Our reference: ECM 8375601
Contact: Gavin Cherry
Telephone: 4732 8125

12 October 2018

Notice of Exhibition – Nepean Hospital and Integrated Ambulatory Services Redevelopment (Stage 1) (SSD 8766) at 35 – 65 Derby Street, Kingswood

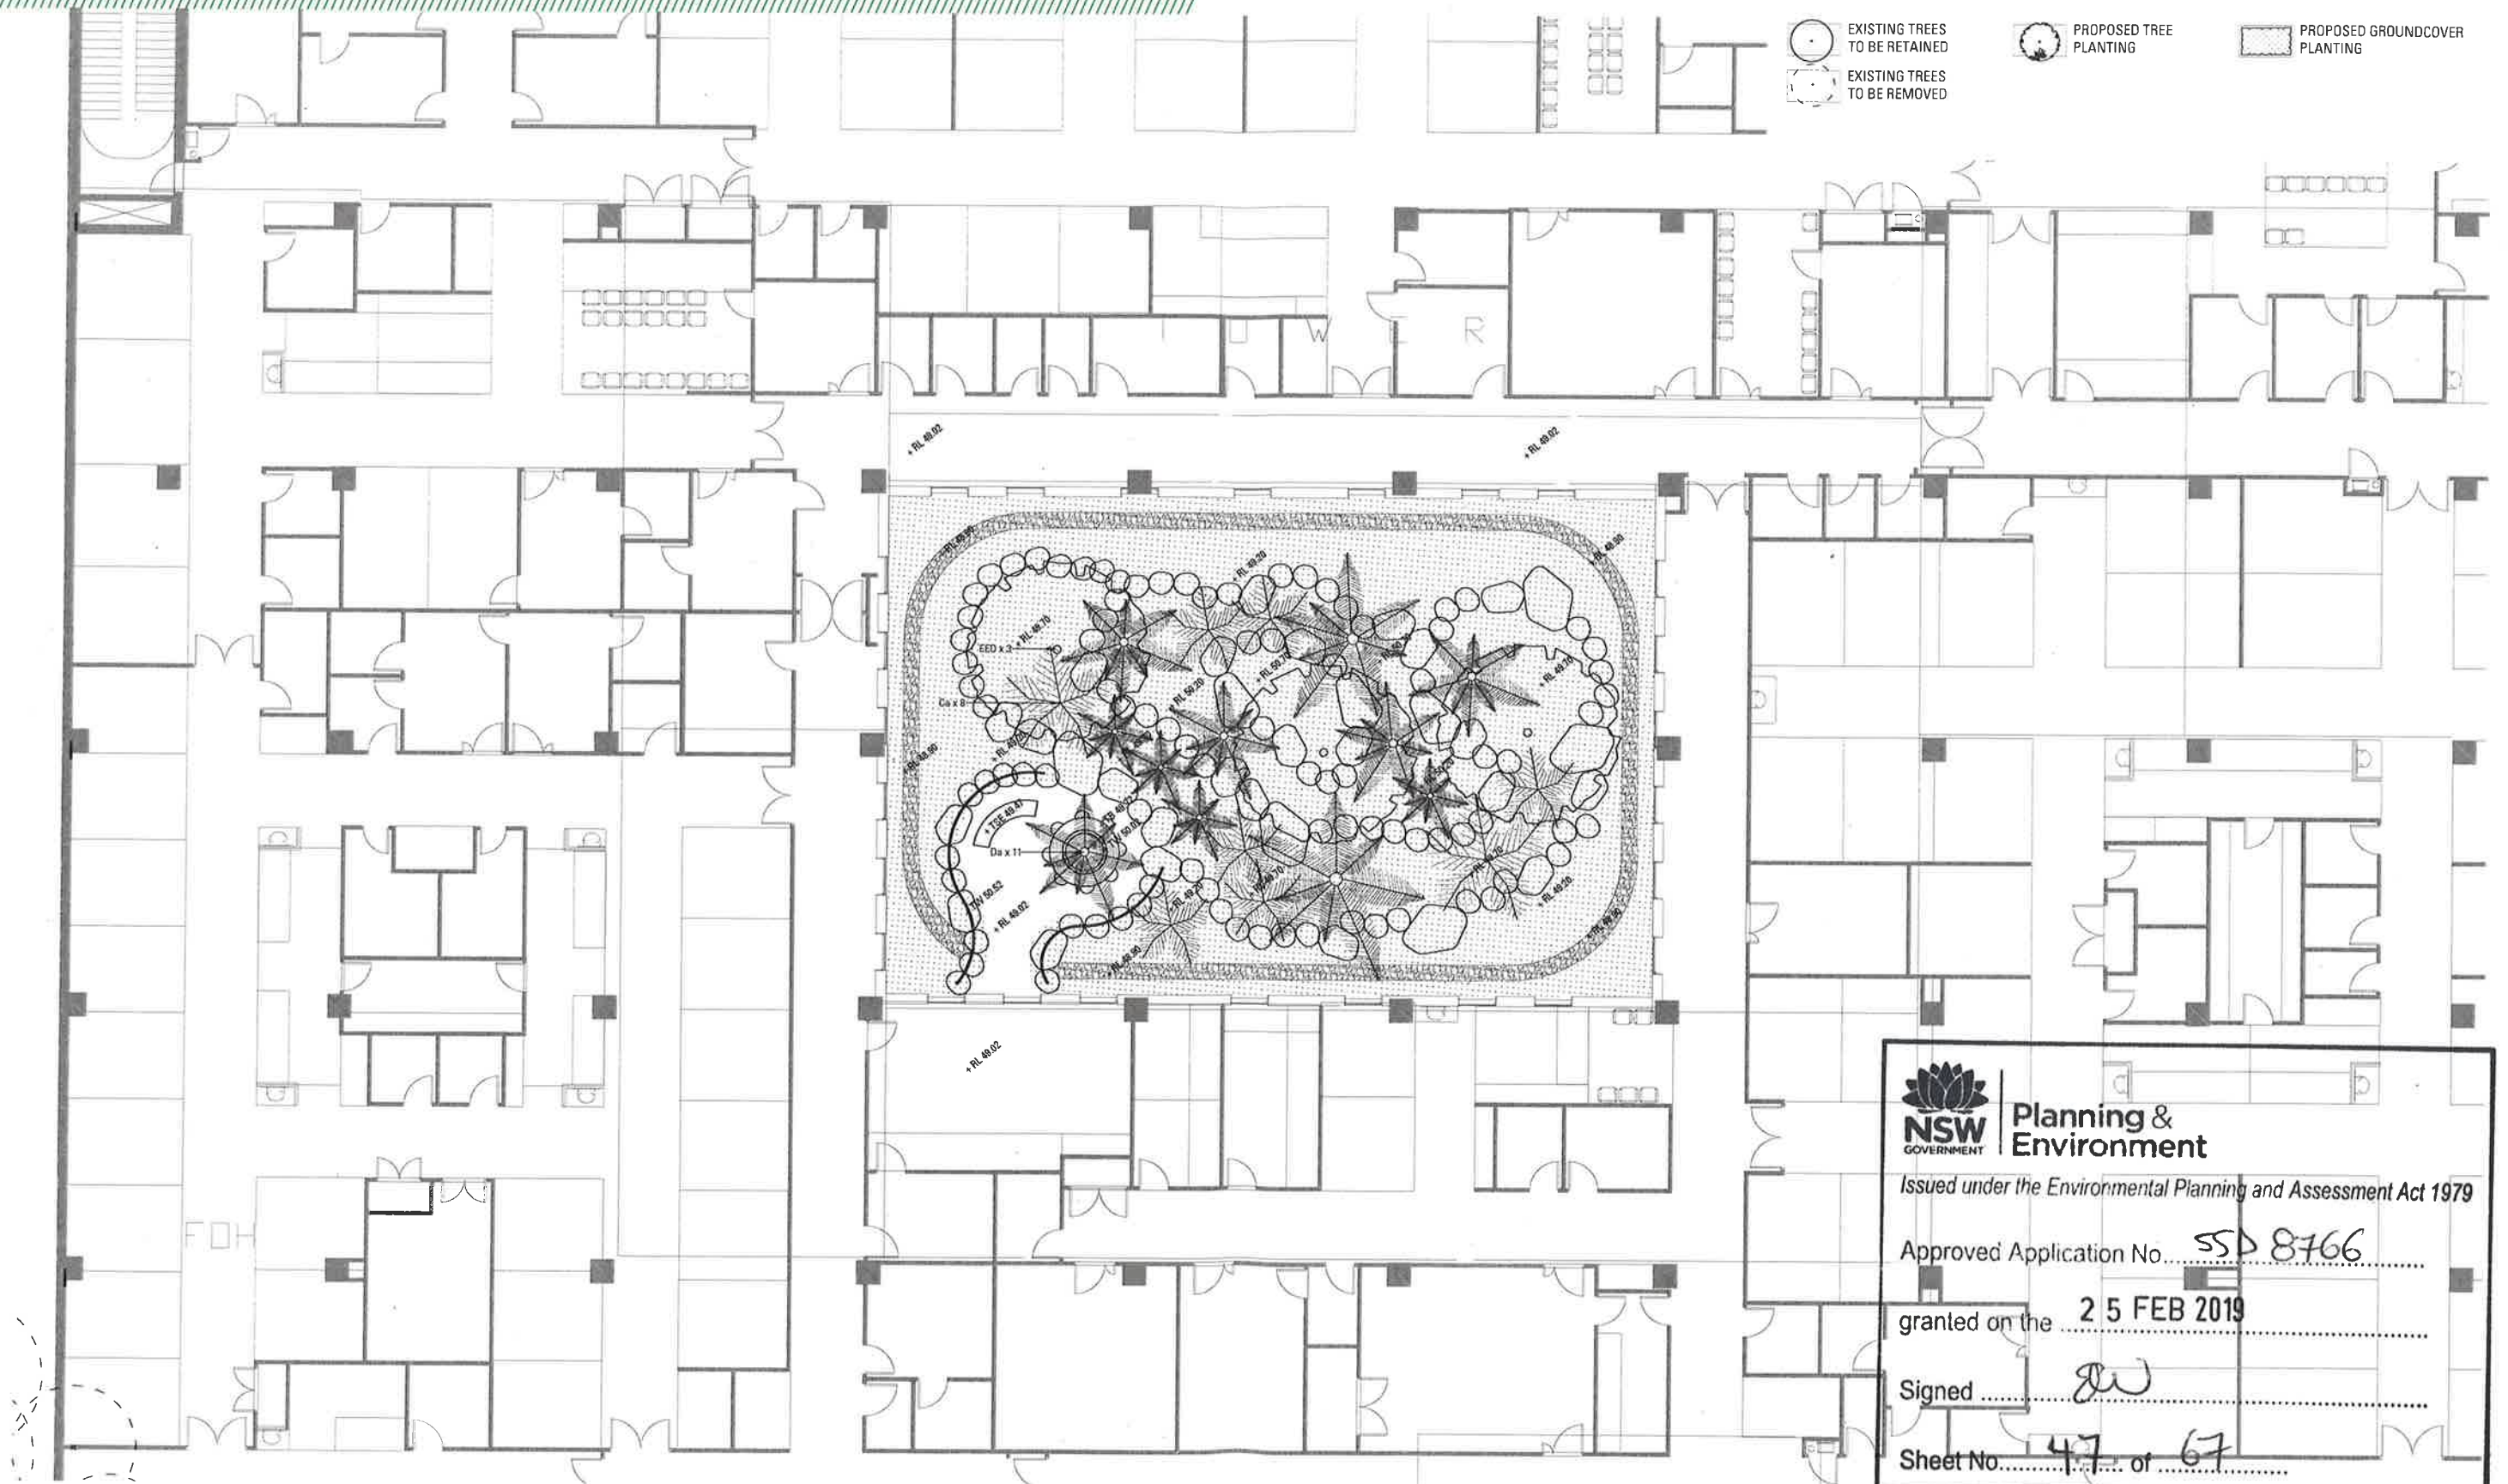
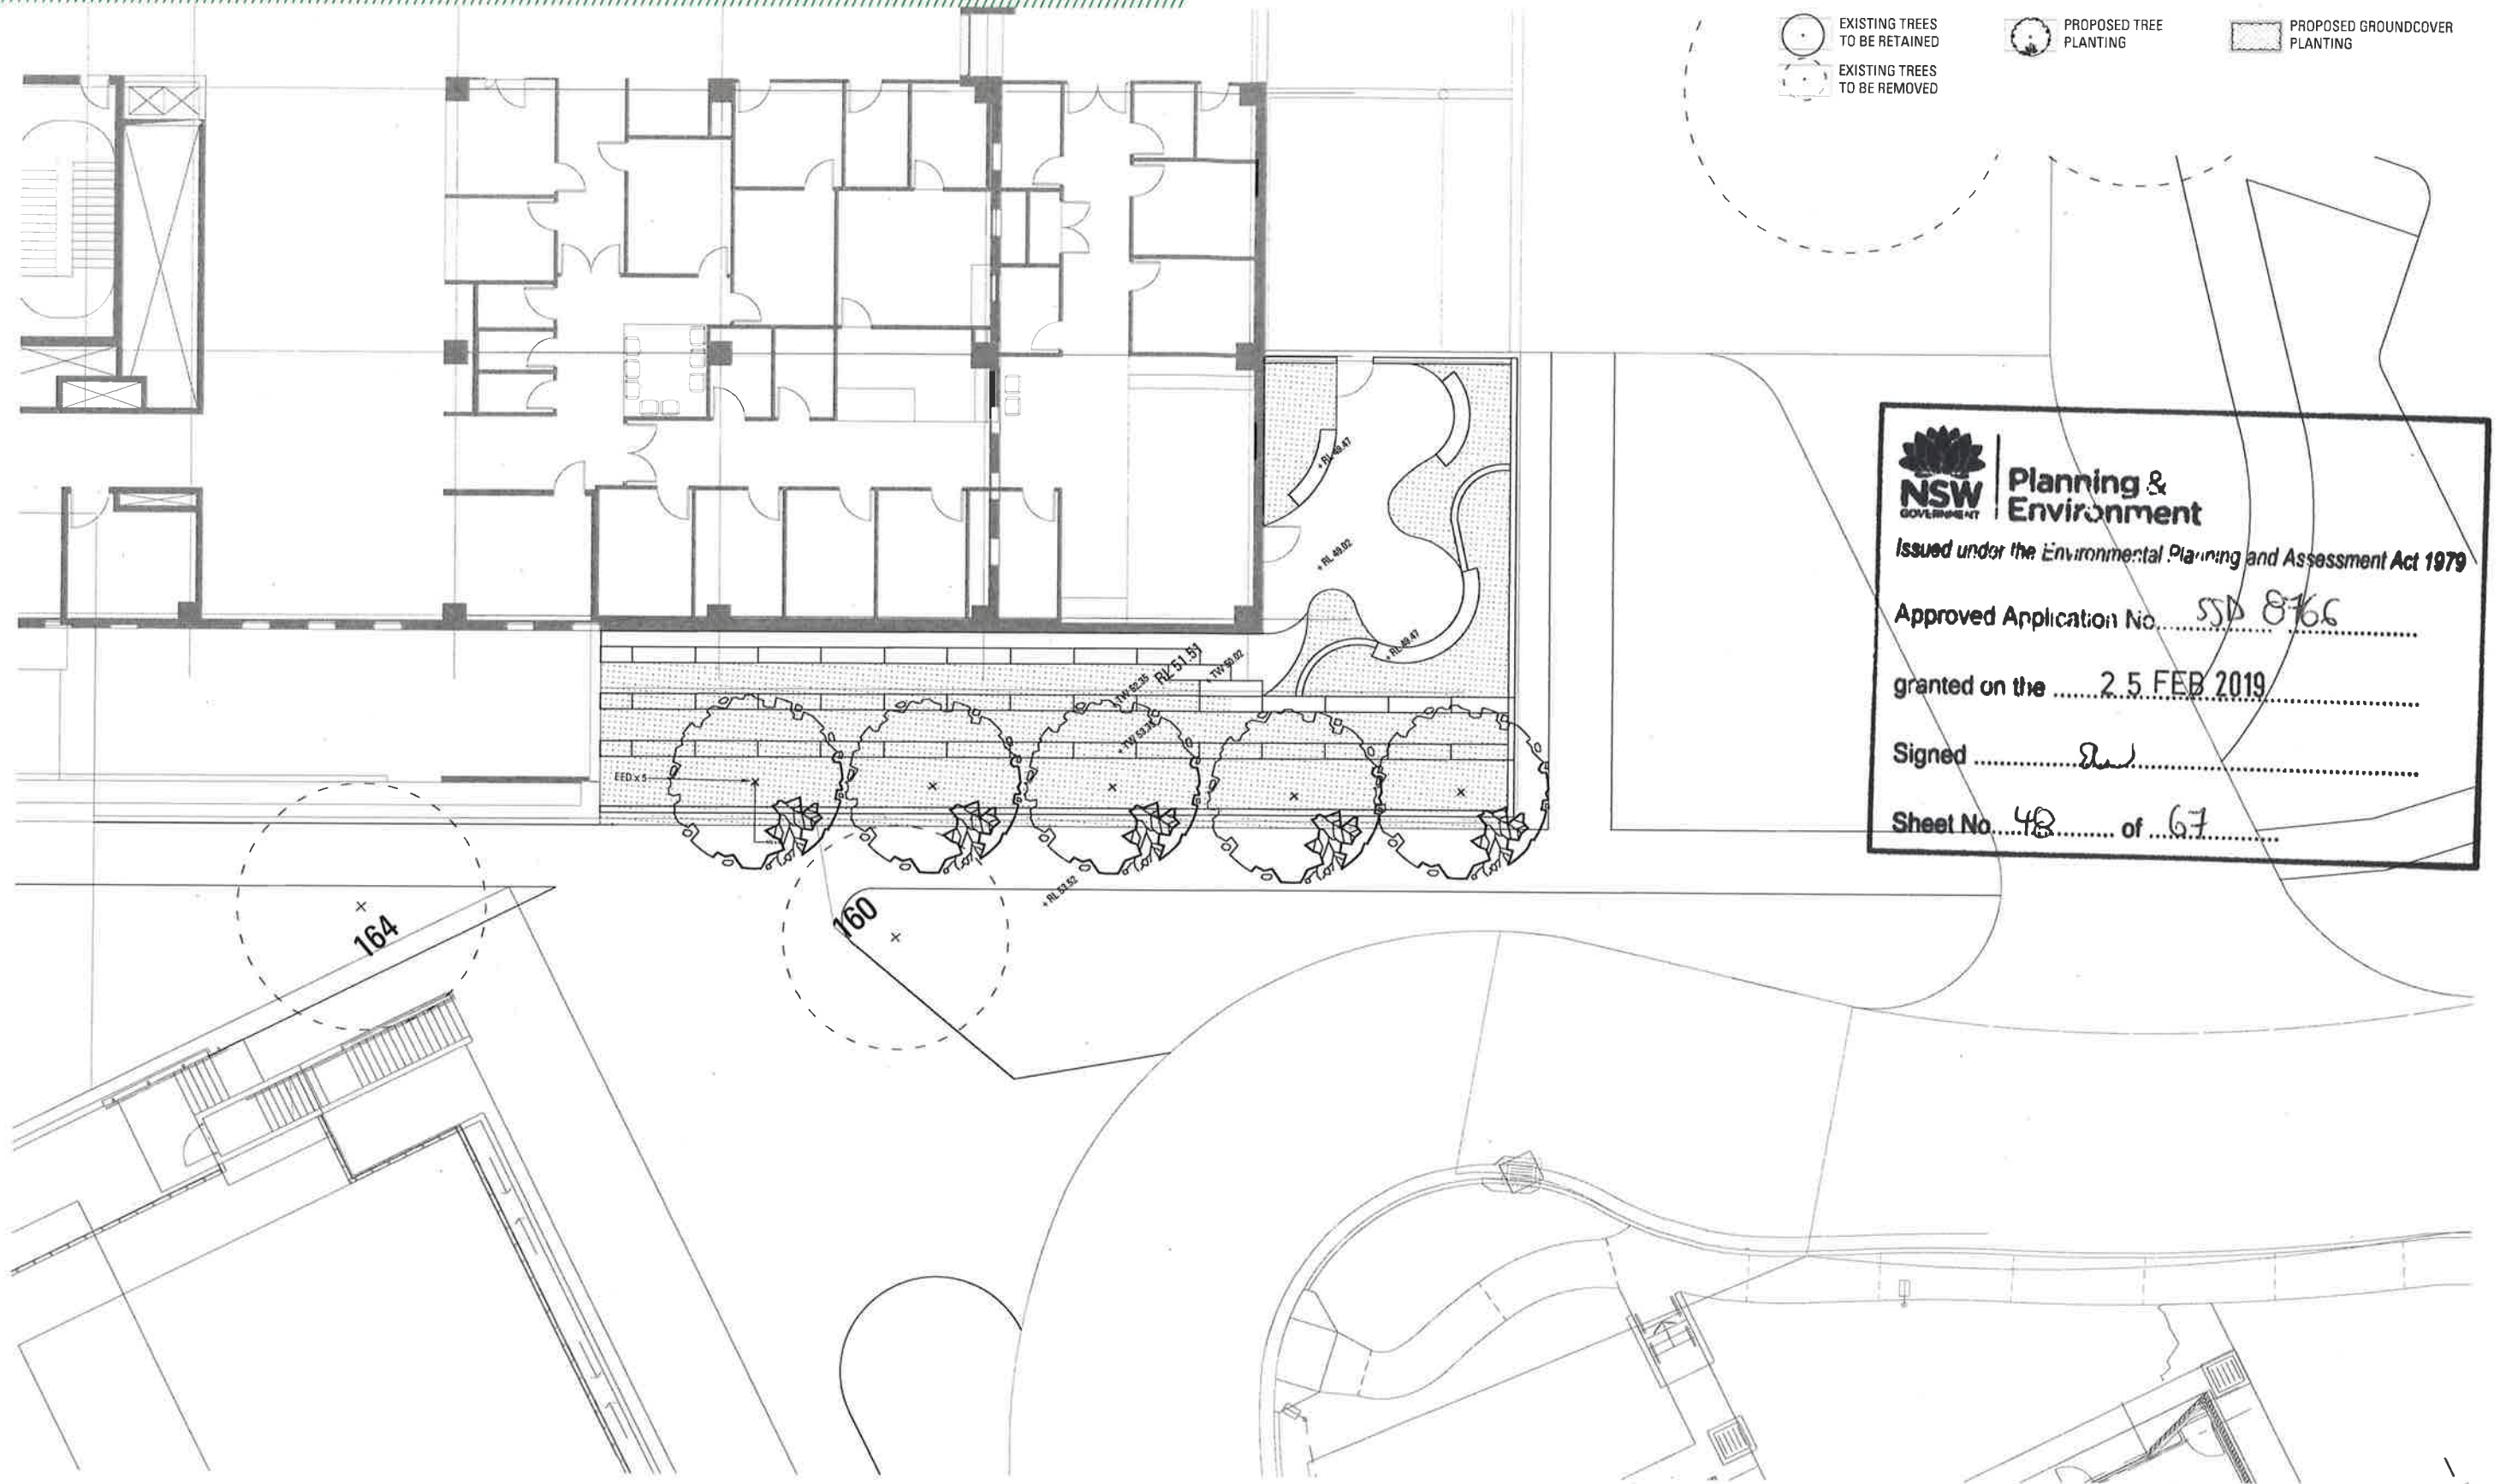
The landscape theme and planting design should be revised to reflect the urban landscape setting in which the site sits, with suitable spatial separation between large canopy trees and plant species and densities suitable for this space.

DRAINAGE LINE A

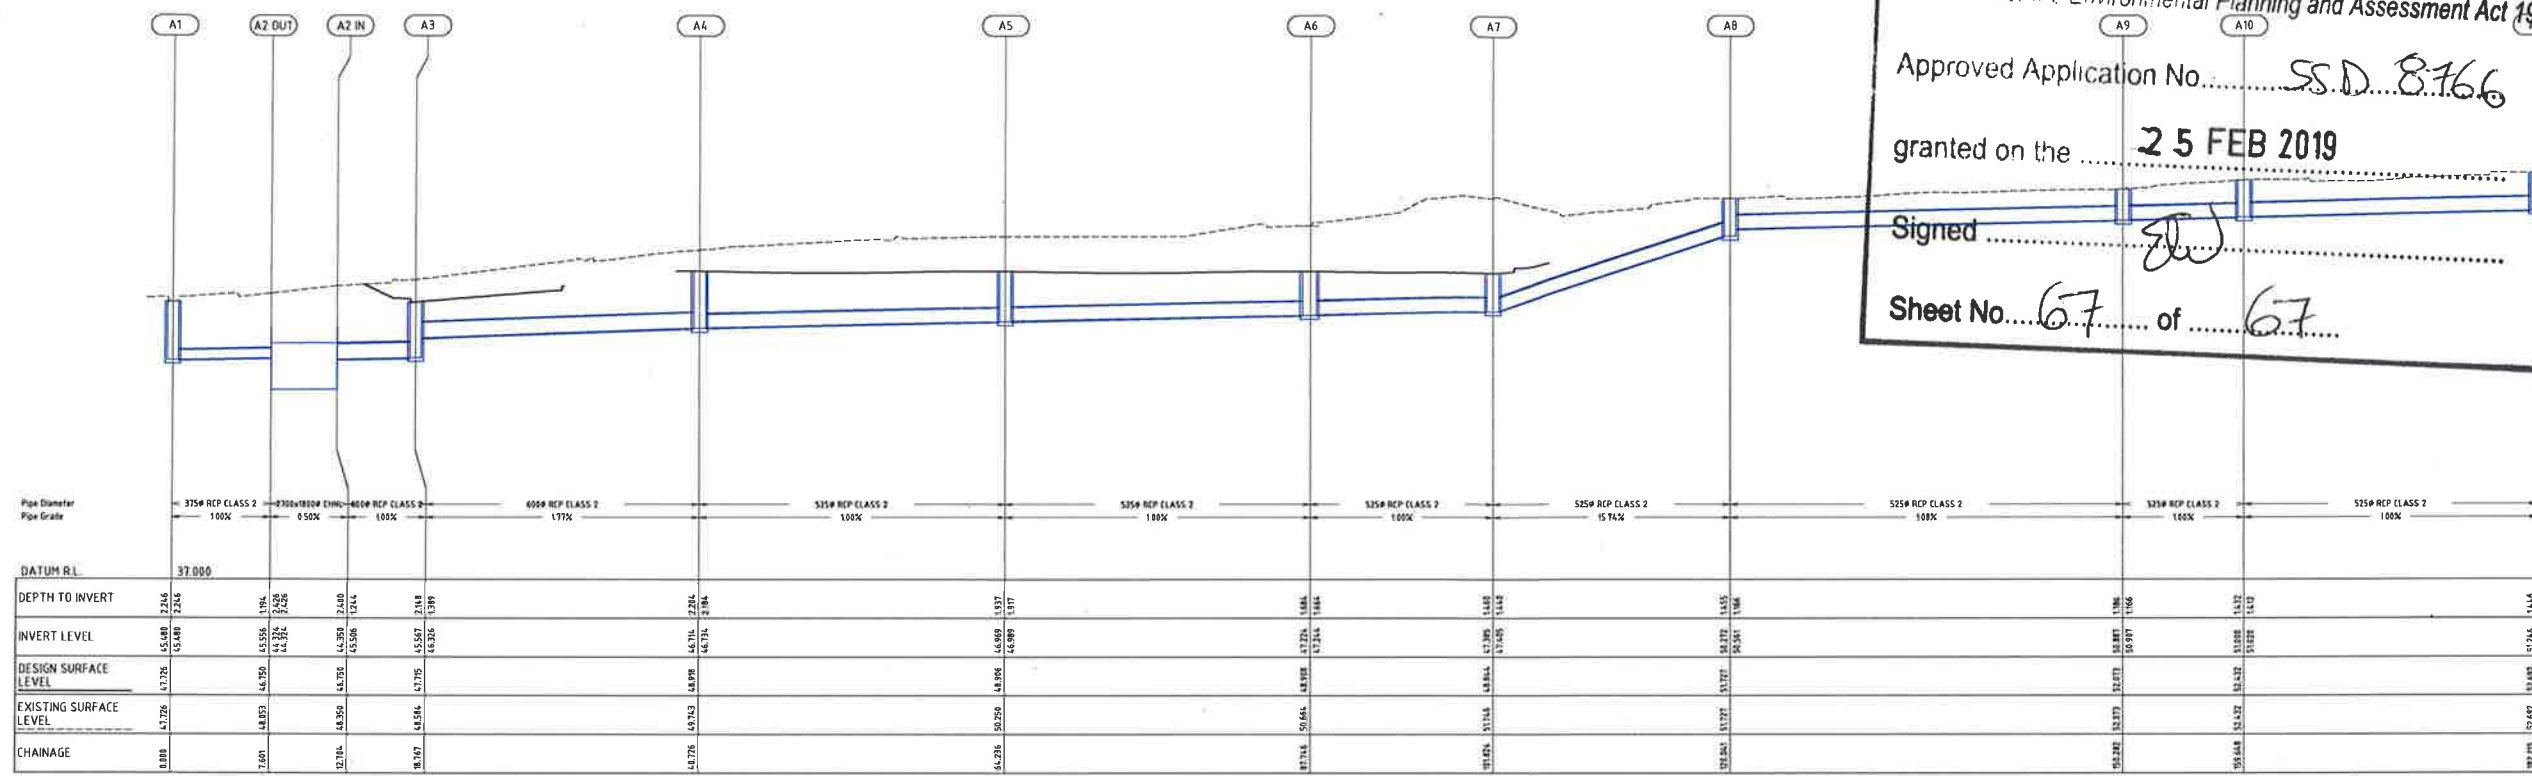
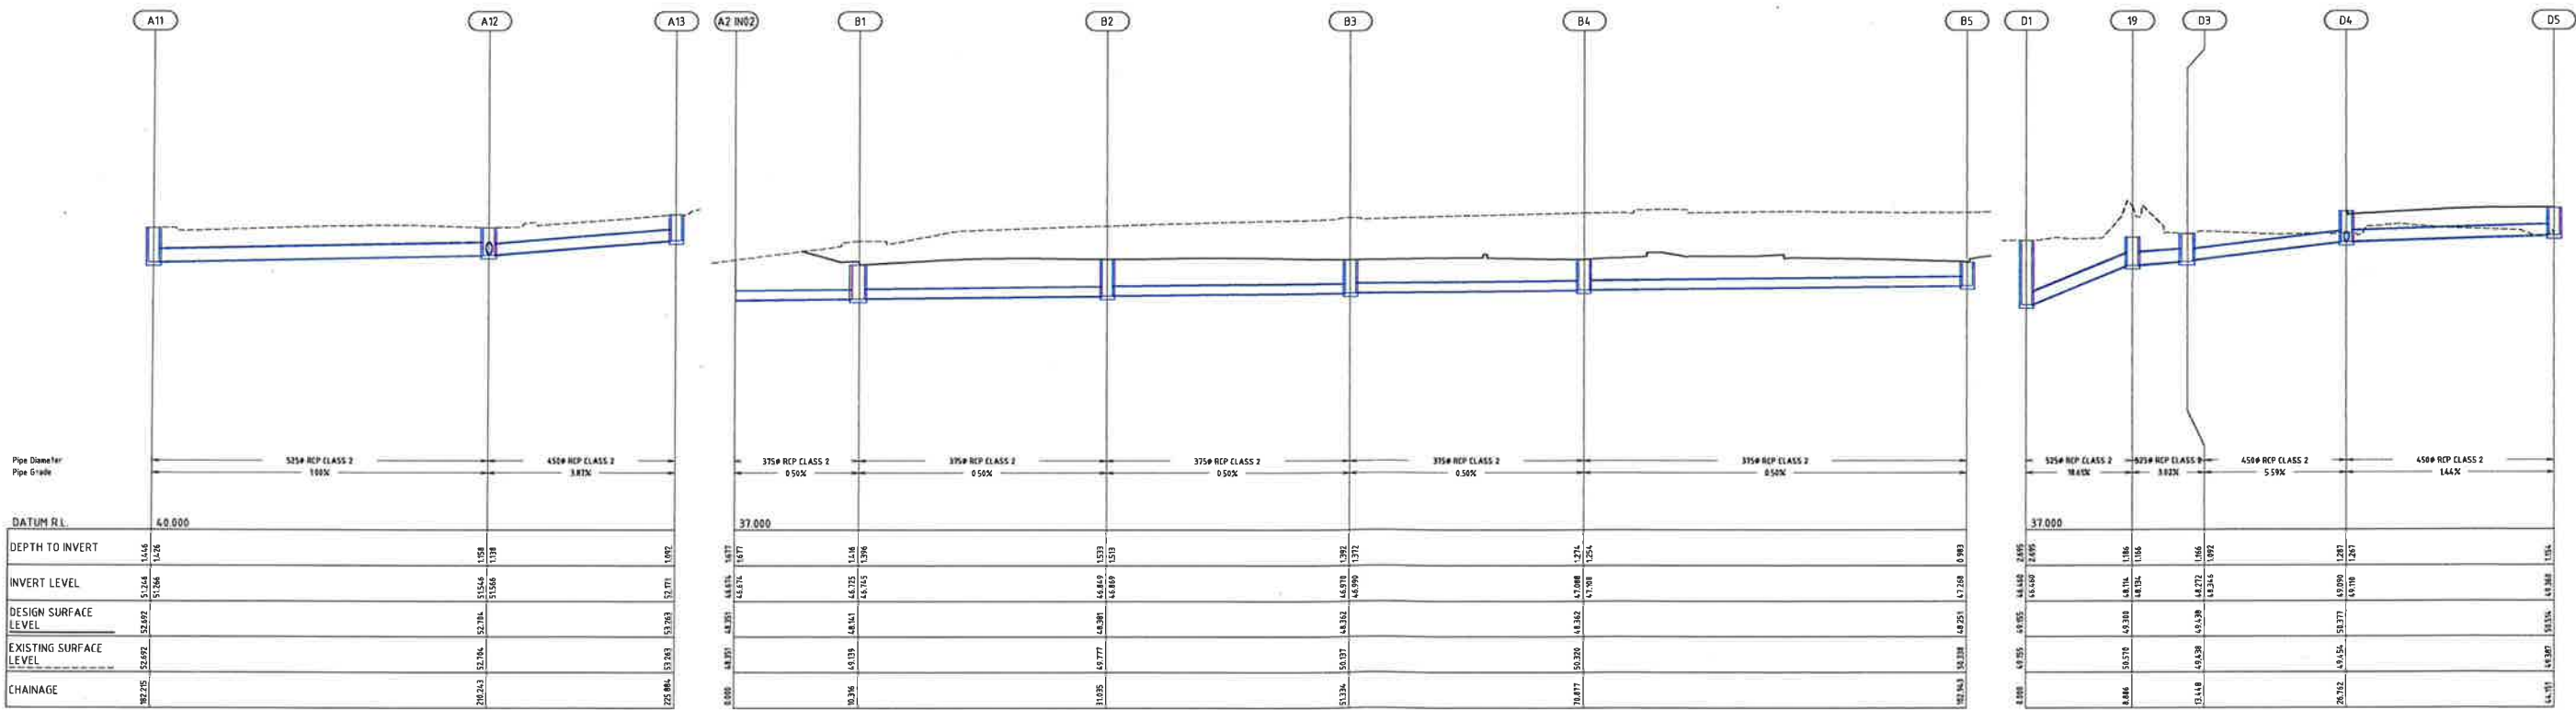
- Cross section details for the proposed vegetated swale as well as the Stormfilter chamber and cartridges should be provided on the Stormwater Drainage Plans.
